The Member-Secretary,  
Chennai Metropolitan  
Development Authority,  
No.1, Gandhi Irwin Road,  
Egmore, Chennai-600 008.

Letter No.C3/37213/2002, Dated:23.5.2003.

Sub: CMDA - Planning Permission - Multi-Storeyed building - Proposed construction of Double Basement Floor + Ground Floor + Mezzanine Floor + 6Floors for Hotel building at T.S.No.5/3,5/4, 5/5 & 5/23, Block No.5, Door No.188, N.S.K. Salai, (Arcot Road) Saligramam, Chennai - Proposal Recommended & Forwarded to the Government - Regarding.

PLAN SHOWING THE BUILINGS TO BE DEMOLISHED OR RETAINED AT 183, N.SK. SALAI, VADAPALANI, CHENNAI - 600 026, EGMORE NUNGAMBAKKAM TALUK,.

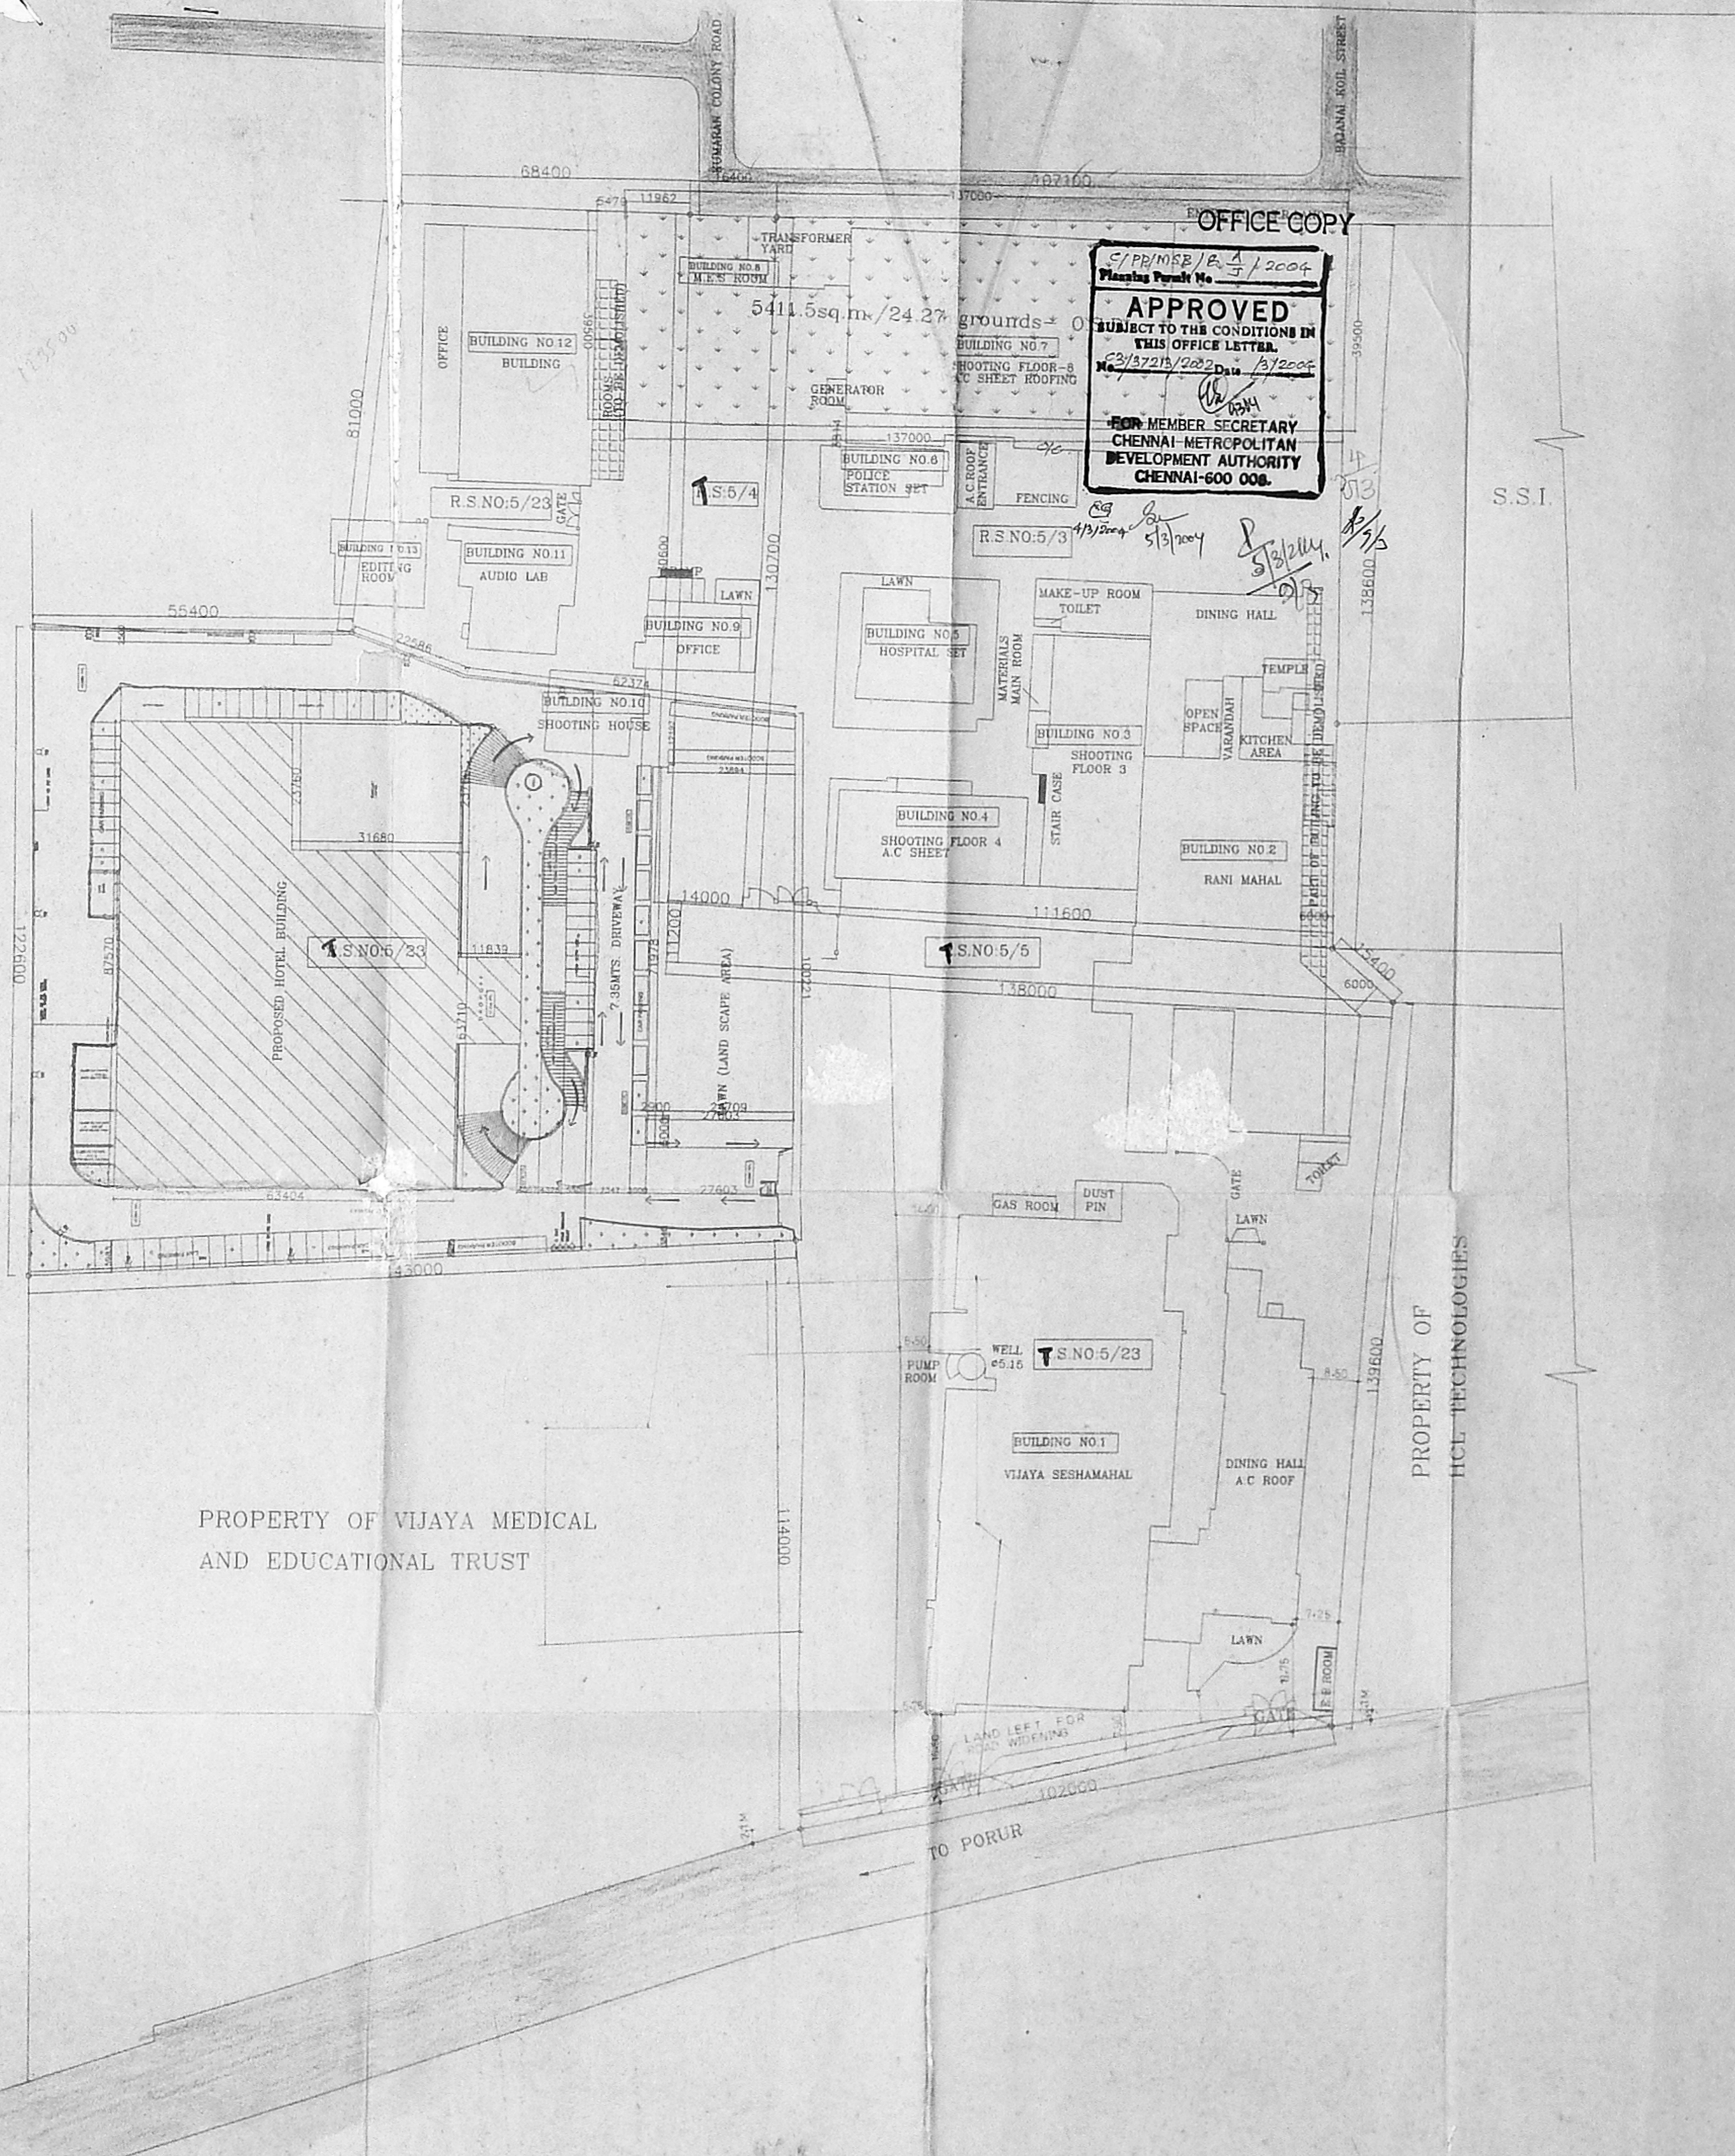
1. Revised Plan showing required street alignment portion for Arcot Road and incorporating all the Director of Fire Service conditions.
2. corrected General Power of Attorney for the entire extent of the site under reference.
3. Approved demolition plan from Chennai Corporation for the building/structures marked for demolition.
4. No Objection Certificate from Metrowater for the swimming pool proposed in the first floor.

1. Revised plan showing required street alignment  
 2. Corrected general power of Attorney for the entire extent of the site under reference  
 3. Approved demolition plan from Chennai Corporation for the building/structures marked for demolition  
 4. No Objection Certificate from Metrowater for the swimming pool proposed in the site plan

6. The applicant has furnished corrected CPA, NOC, from metrowater revised plans incorporating DFS conditions, and the street alignment portion for Arcot Road, in the reference 7th cited. The applicant has furnished the receipt of the application for obtaining approved demolition plan from Chennai Corporation.
